Comments for Planning Application 20/01281/FULL

Application Number: 20/01281/FULL

Address: 70 Princes Road Kingston Upon Hull HU5 2SE

Proposal: Change of use from a 4 bedroom single family dwelling house (C3 use) to a 5 bedroom HMO (C4 use)

Proposed Floor Plan

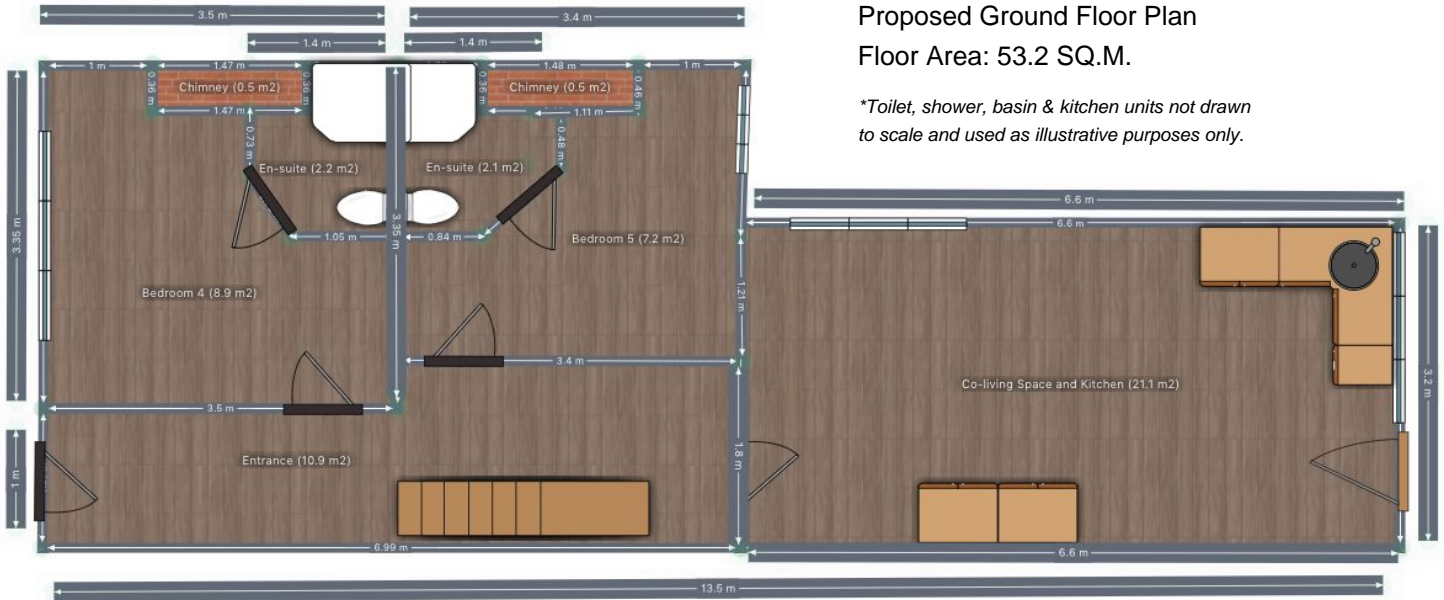
The developer seeks to modify a family house and adapt it to provide 5 en-suite bedrooms that are of mean proportions giving inadequate space for an individual to lead a meaningful existence. The proposed combined living area and kitchen would also provide an inadequate and probably unpleasant environment. Each proposed bedroom seems to contain an en-suite toilet facility but there is no detail as to how these would be ventilated.

Figure 4. External wall insulation system.

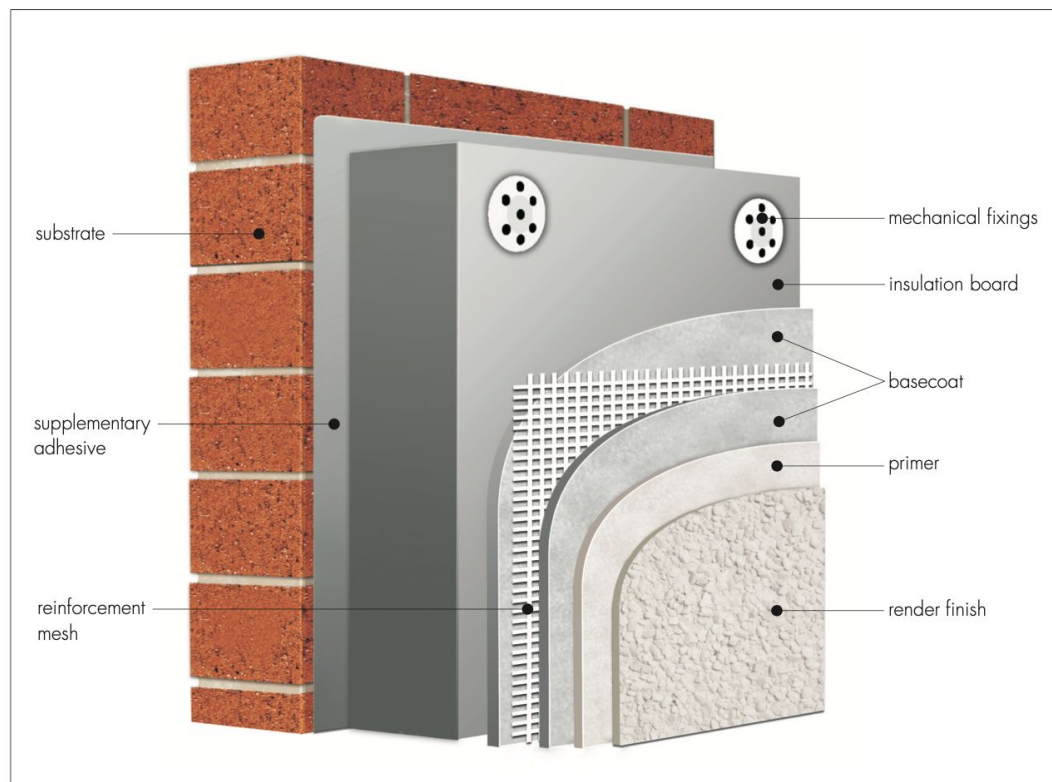
It is evident from the developer's promotional photographs of previous projects that the materials and fittings in use are of the cheapest variety. Externally, the proposal is to clad the building with an external insulation product whilst at the same time retaining 'original features.' The proposal would actually obliterate all original features and present a facsimile façade. The original brickwork of the building is quite fine incorporating dentil courses and bandings. Lintels and door arches are in painted sandstone. On the front aspect the proposed insulation will encroach on pavement space which is something that should be discouraged. If rain water pipes are fitted on the surface of the insulation, total encroachment will be doubled. This encroachment is particularly problematic in an area where the custom is to store wheelie bins on the pavement.

The polystyrene insulation system that is proposed is not classified by the manufacturer as 'NON-COMBUSTIBLE.' This is particularly hazardous when combined with plastic windows and the local custom of storing domestic waste in plastic containers on the pavement. This treatment would disrupt the building line and would also be out of keeping with the rest of the street which features
